Applicant: Mr Payne

Proposal: Discharge of conditions 3 (schedule of materials), 4 (Secured by Design principles), 7 (biodiversity method statement), 9 (vehicular electric charging points) of 21/04156/F

Expiry Date: 30 September 2022

Date Drawn: Nov 21	Drawn By: MHG	Scale: varies
Job No: 7030	Drg No: PC1

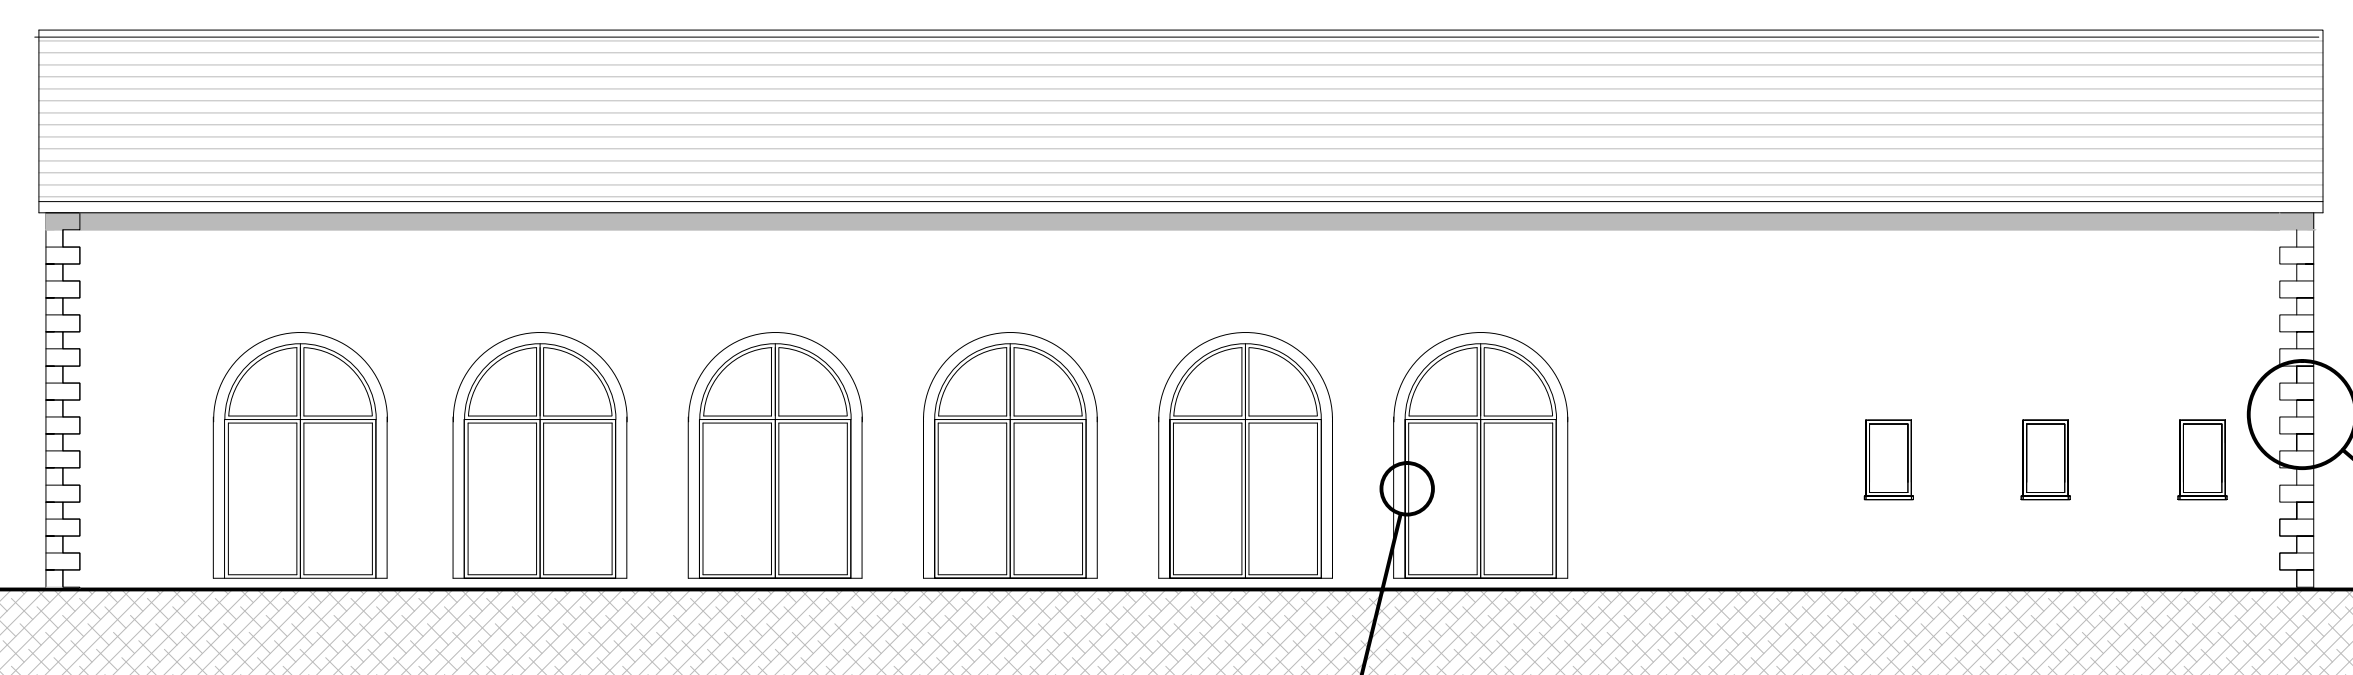
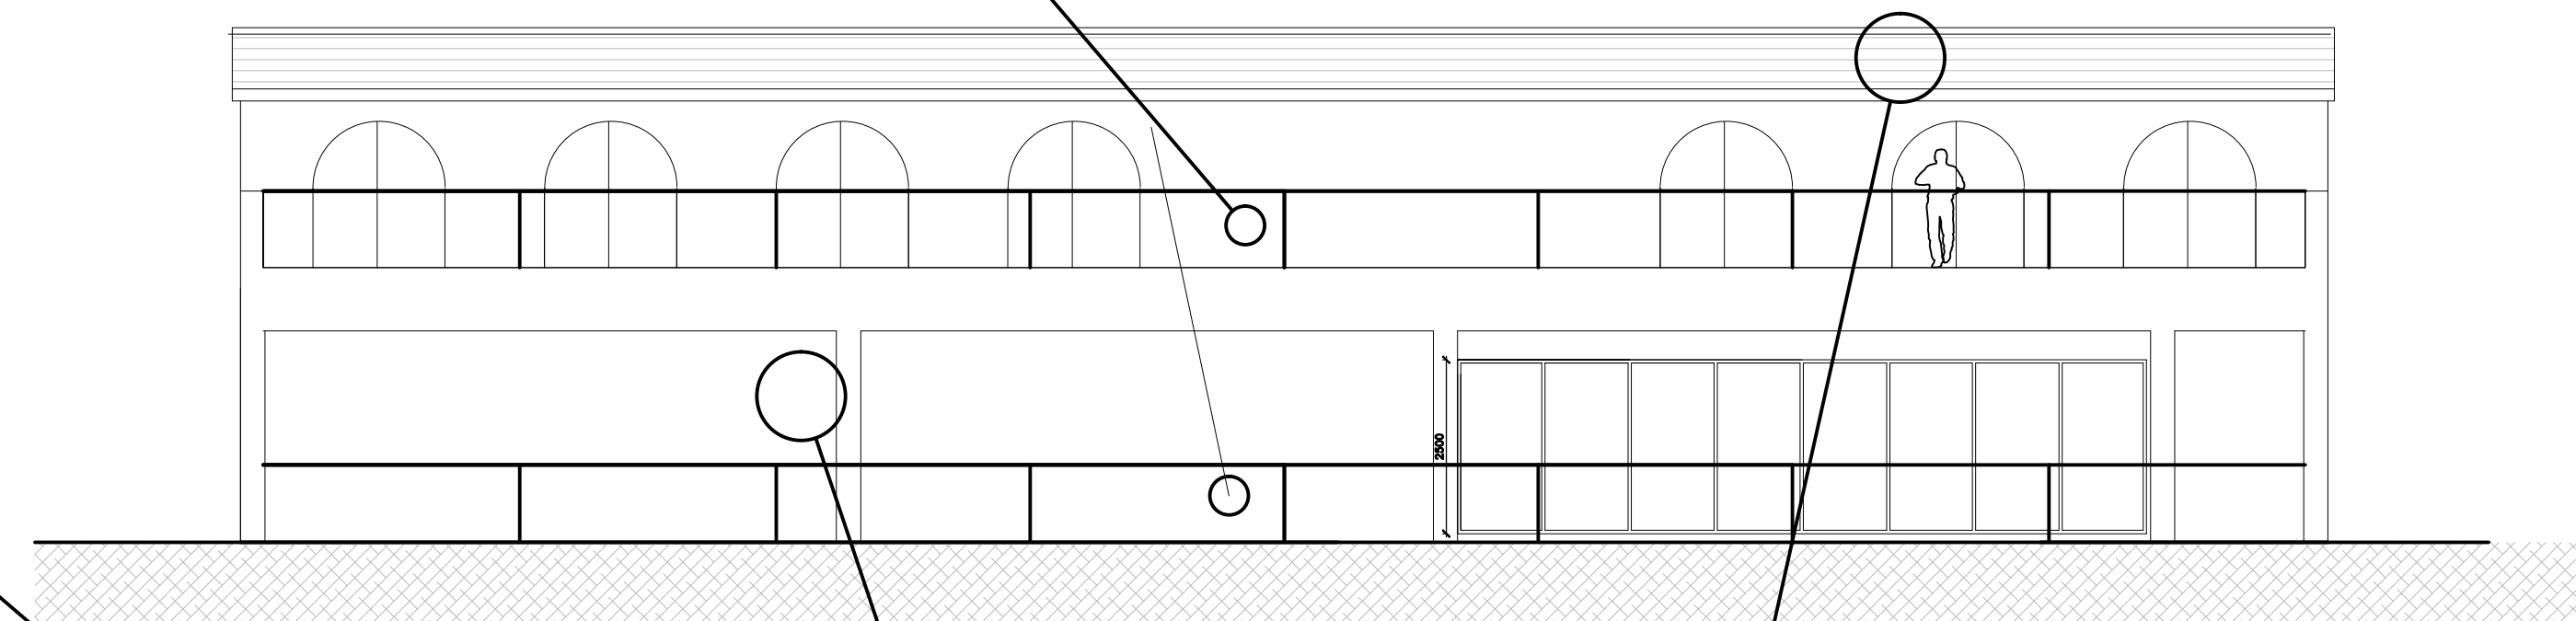
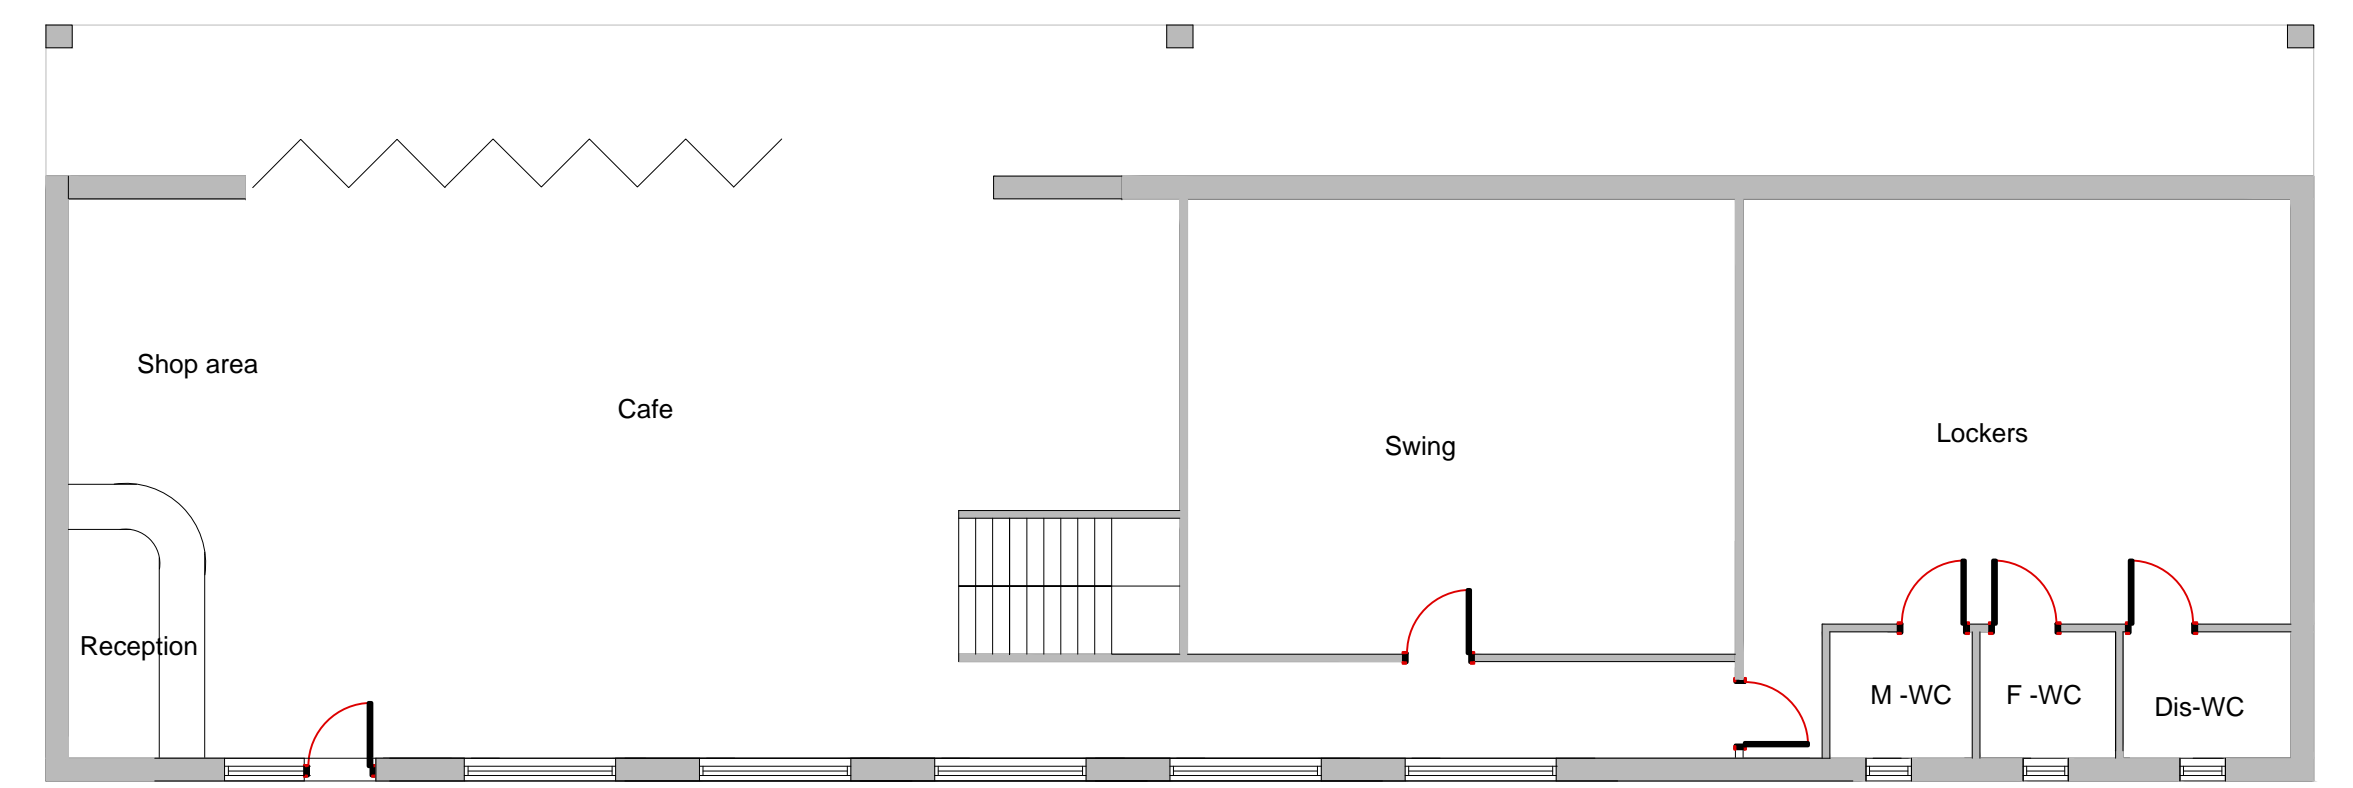
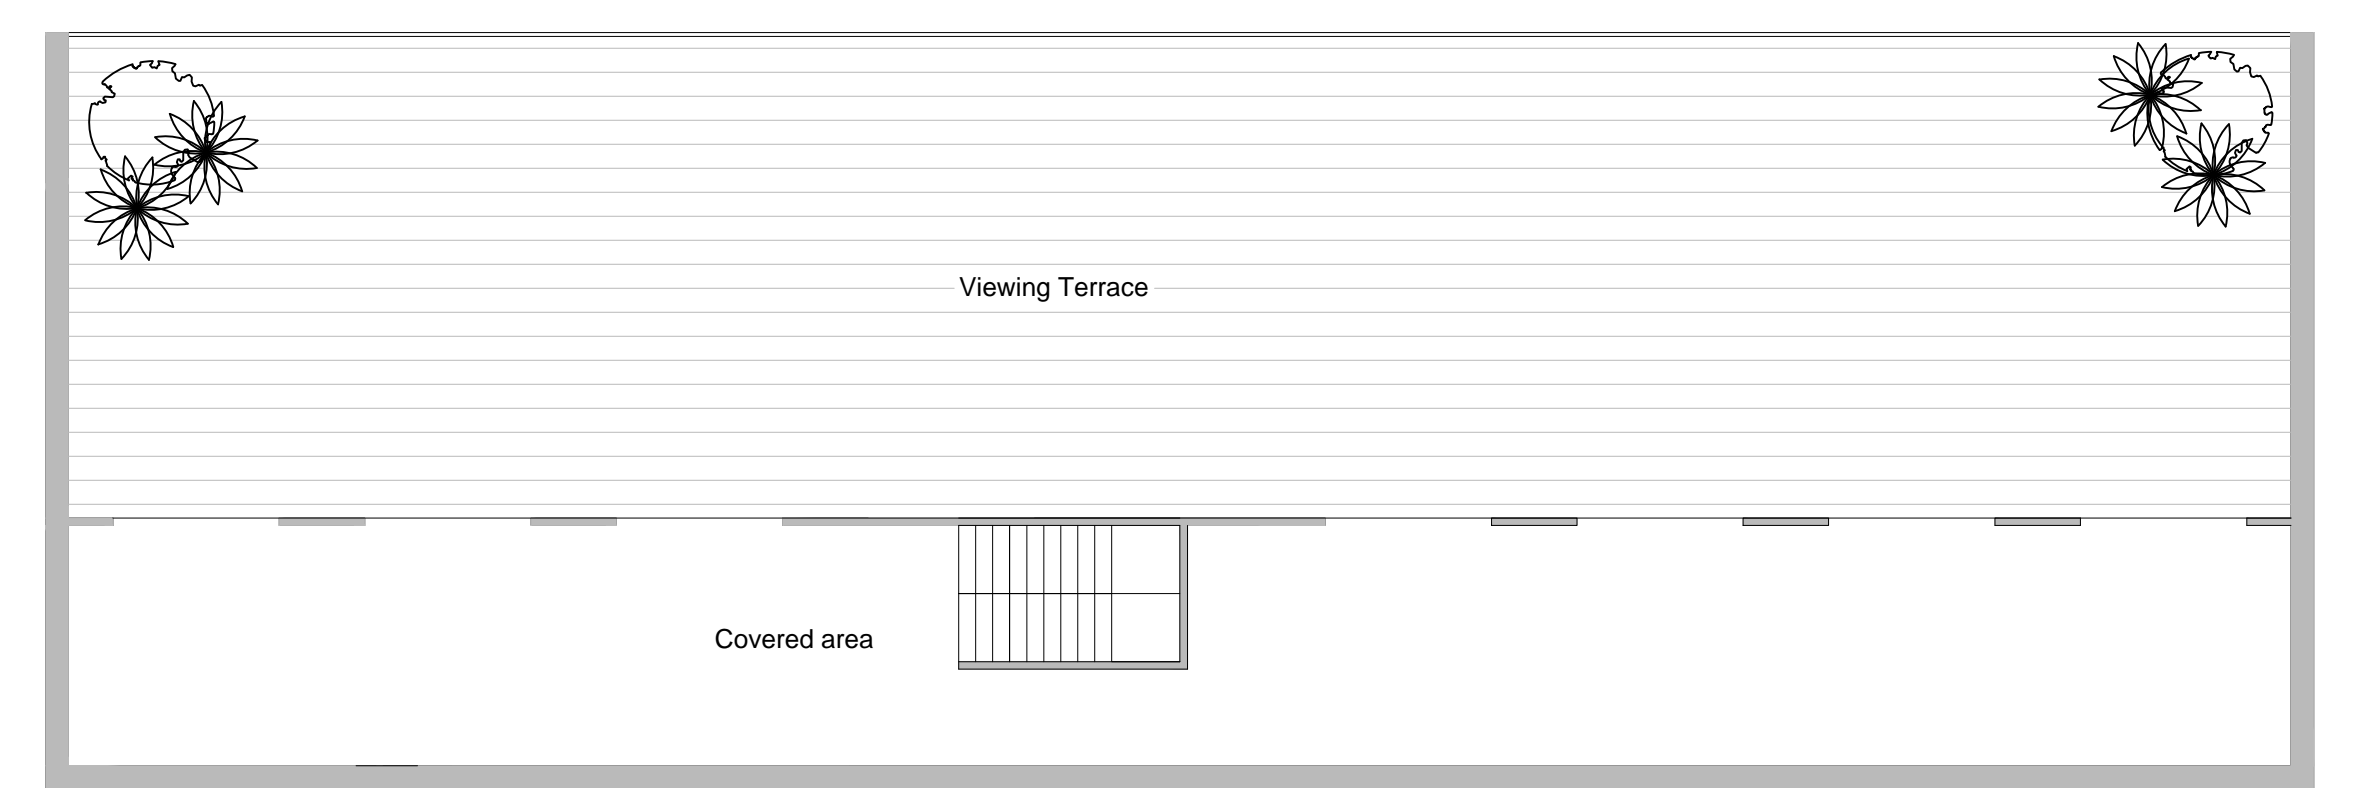
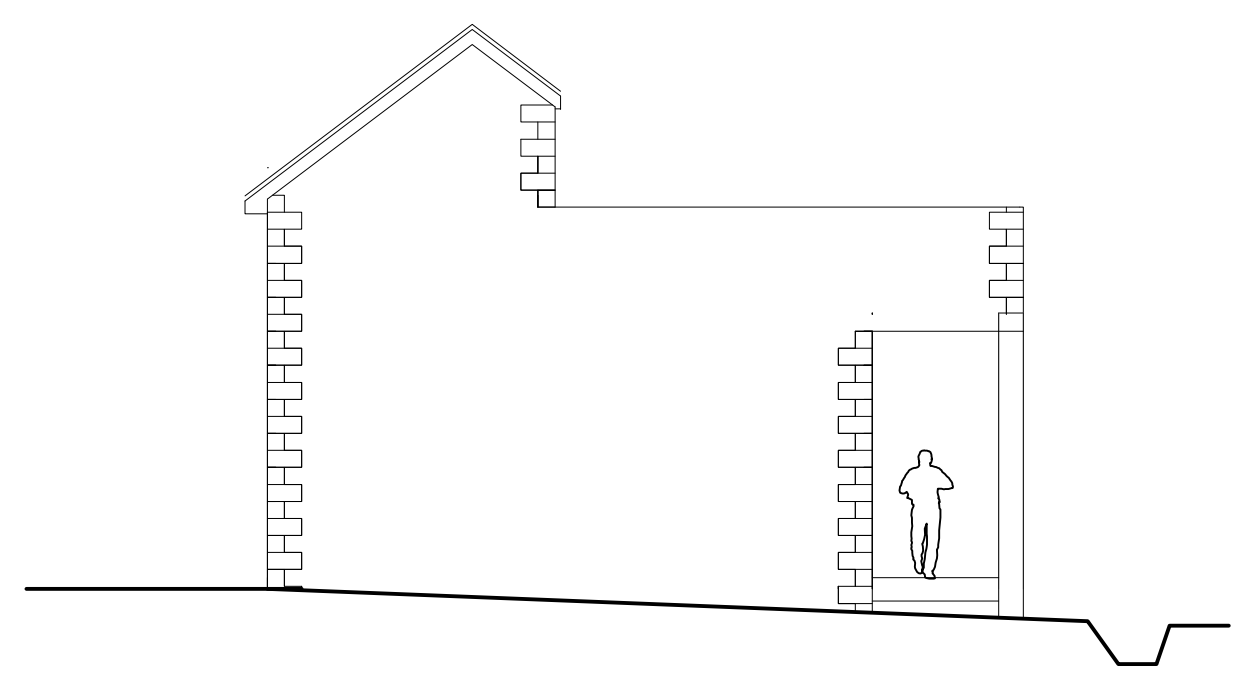
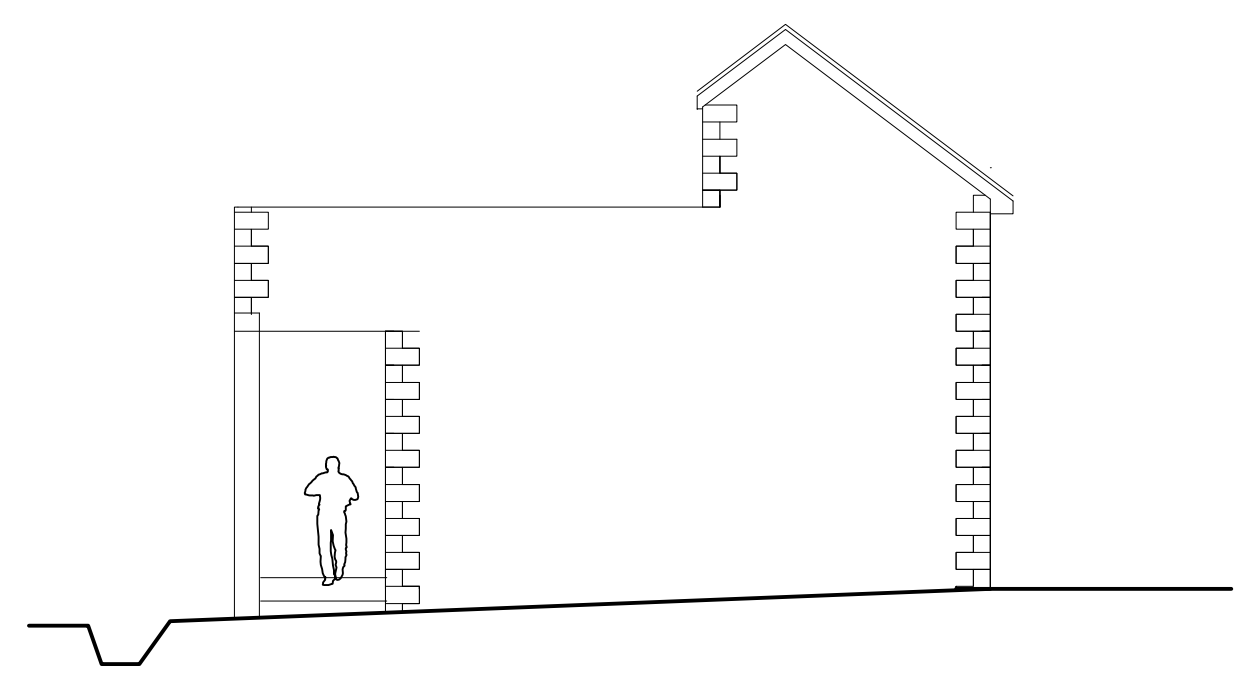
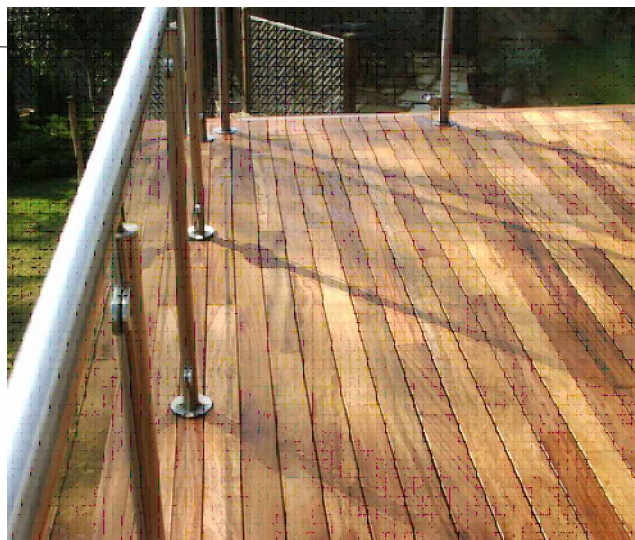
- 2.1. Condition 3 – required a schedule of materials and finishes. This was submitted in the form of Drawing No: PC1 indicating that the stone and mortar, including quoin detail, would match that of the existing hotel. The tiled roof would also match that of the existing hotel. Openings would be black powder coated aluminium, with glass balustrade supported by black metal posts. The decking to the upper terrace would be timber, with cast iron black rainwater goods.

- 6.1. Condition 3 – despite the schedule not including a sample panel of stonework, as requested, an image has been provided of existing stonework upon the existing hotel building that can be used for reference. I consider the choice of materials, matching those used within the wider site, is appropriate. The glass balustrade will avoid this appearing as an intrusive feature. I therefore recommend that this condition is discharged.
- 6.2. Condition 4 – The Agent has provided an explanation of the measures from the Secured by Design document that would be incorporated into the scheme and I consider this to meet the requirement of condition 4.

Materials and finishes in accordance with Drawing No: PC1 received with the original application on 11 July 2022.
